Major Projects – New Request for Advice - Western Sydney University Bankstown City Campus (SSD-9831) (Canterbury-Bankstown)

The supporting documentation provided in support of the State Significant Development has been reviewed, and TfNSW comments are provided in **Attachment A**.

Objective Reference: CD19/08883

DRAWING TITLE  
**PLAN - BASEMENT 1**

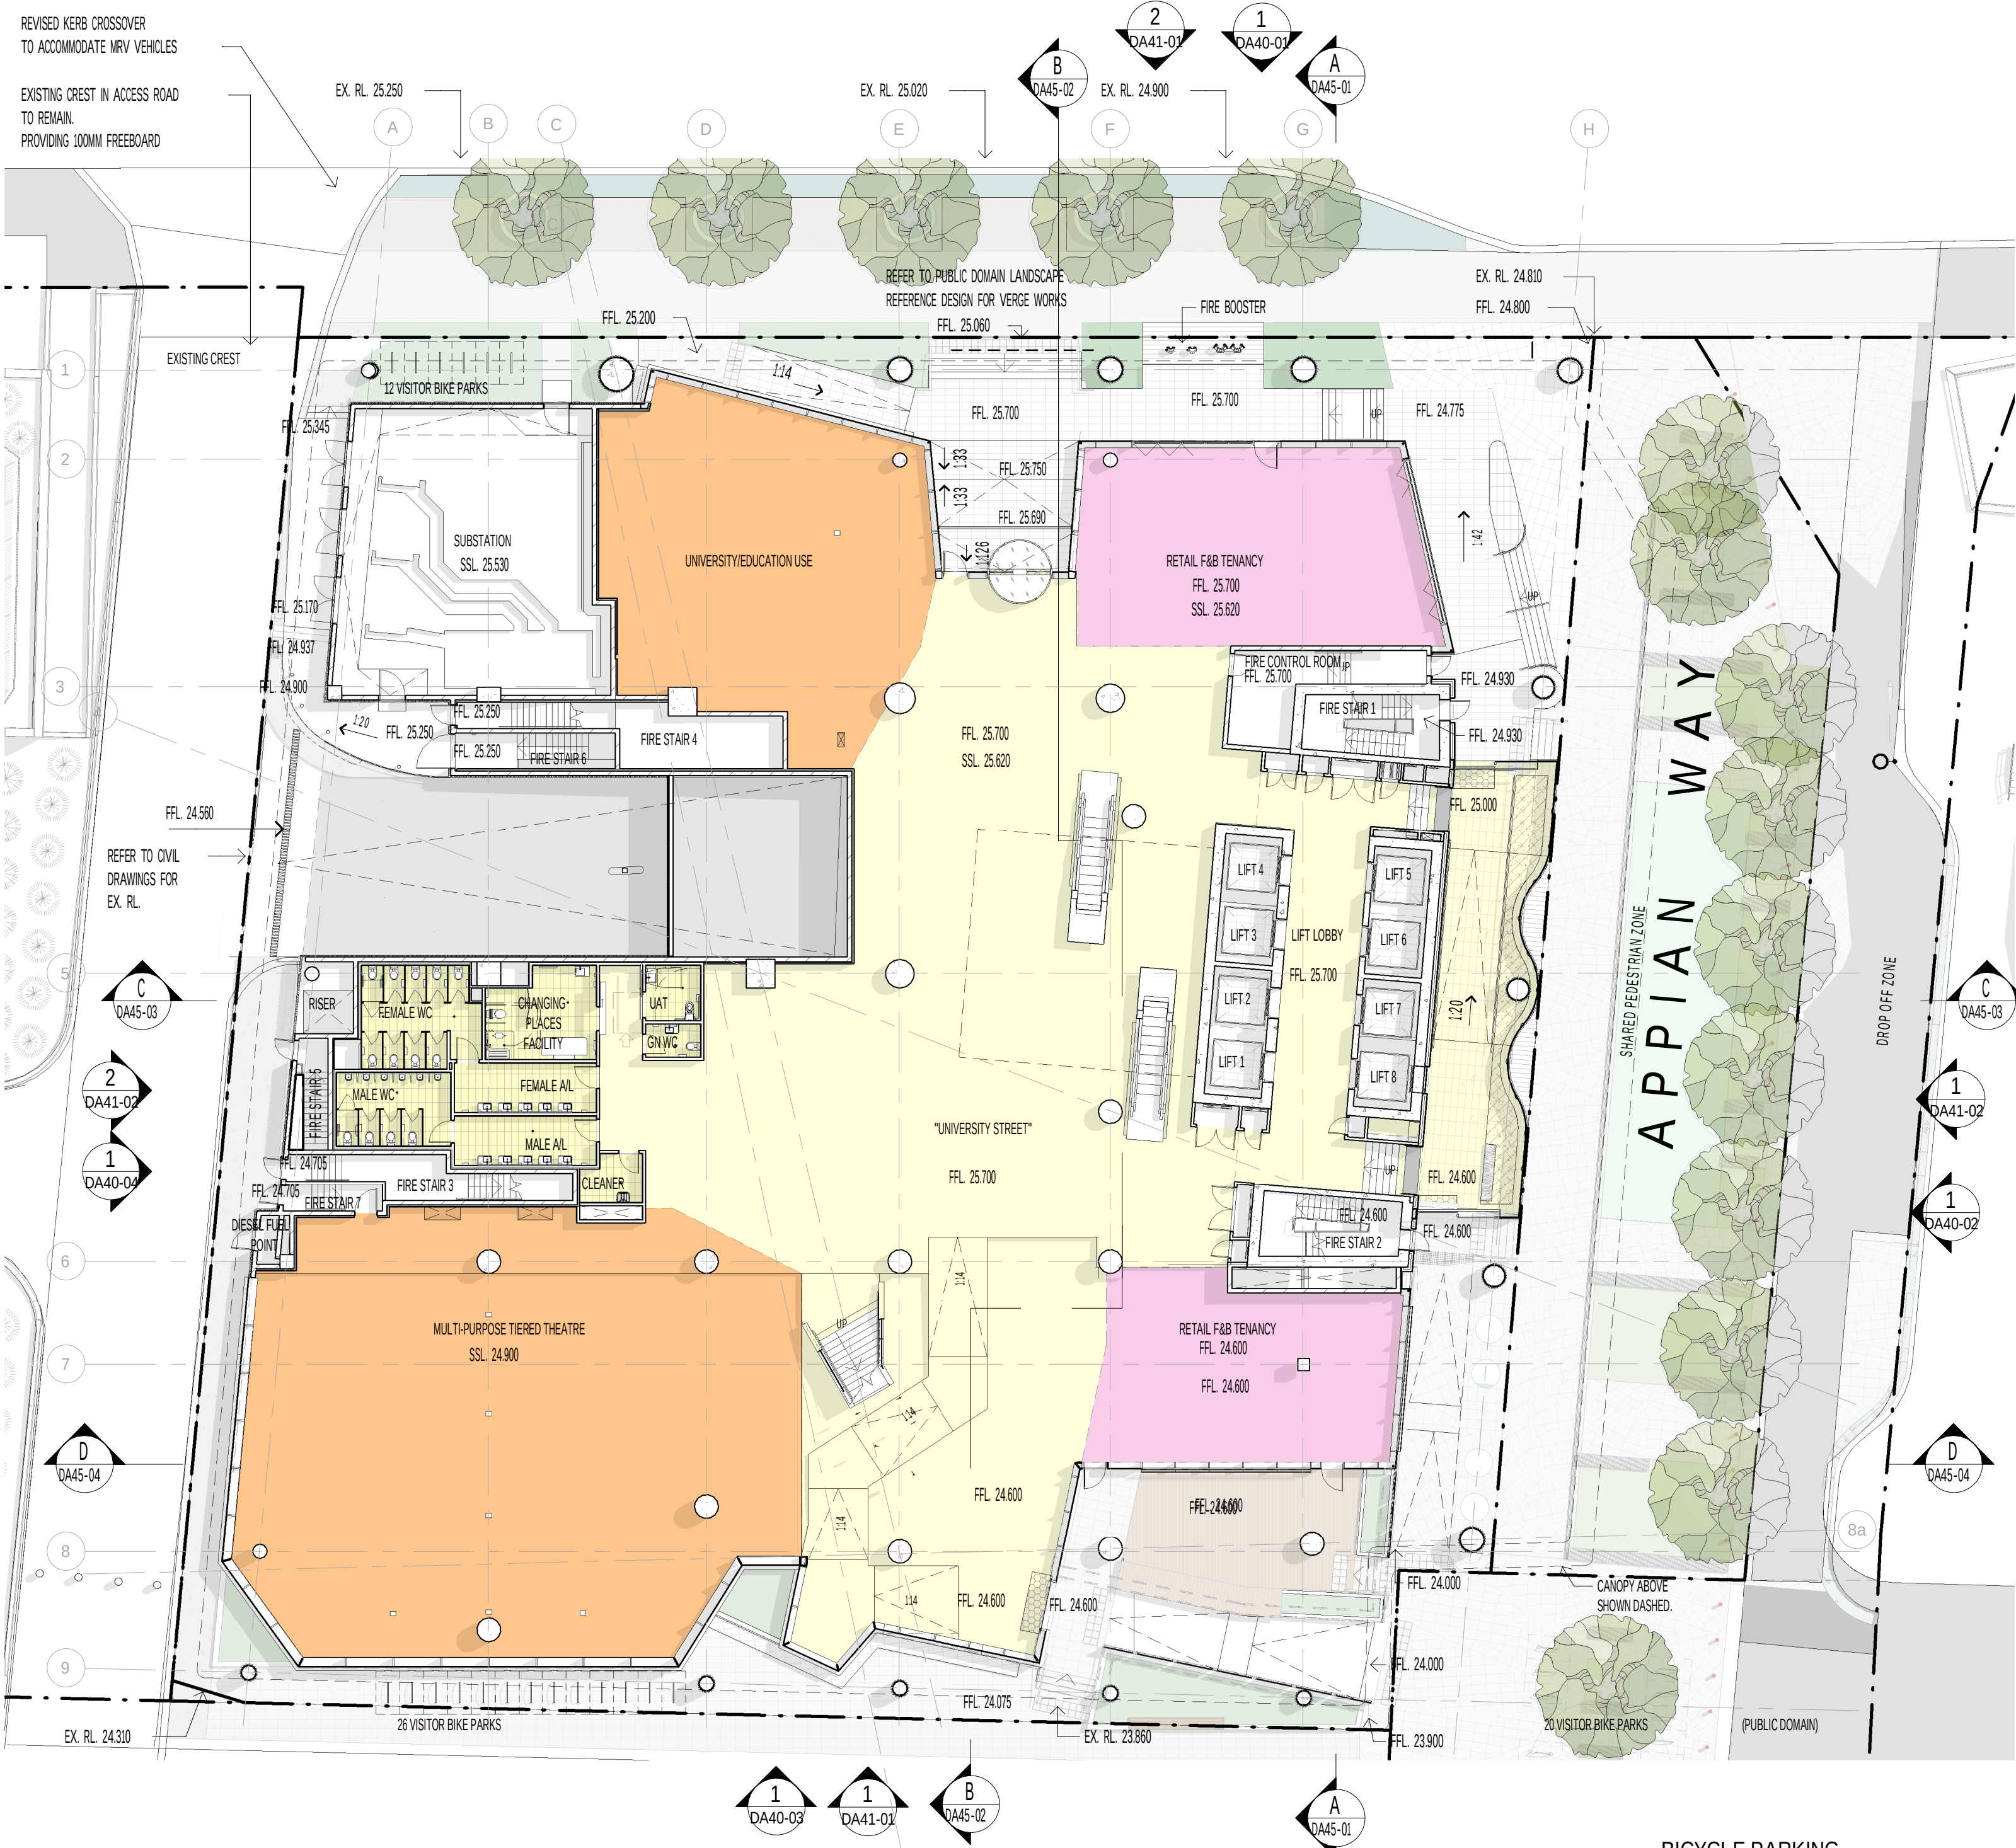
Plans show that card readers will be used for access to the basement area. It appears from the plans that vehicles will need to travel to the contraflow direction to access the relevant card reader. This will present a safety issue when vehicles require access and egress at the same time.

It is recommended that the design of the basement vehicle entry be reviewed and if necessary re-designed to allow for a central median that will accommodate both entry and egress card readers, thus eliminating vehicle conflict.
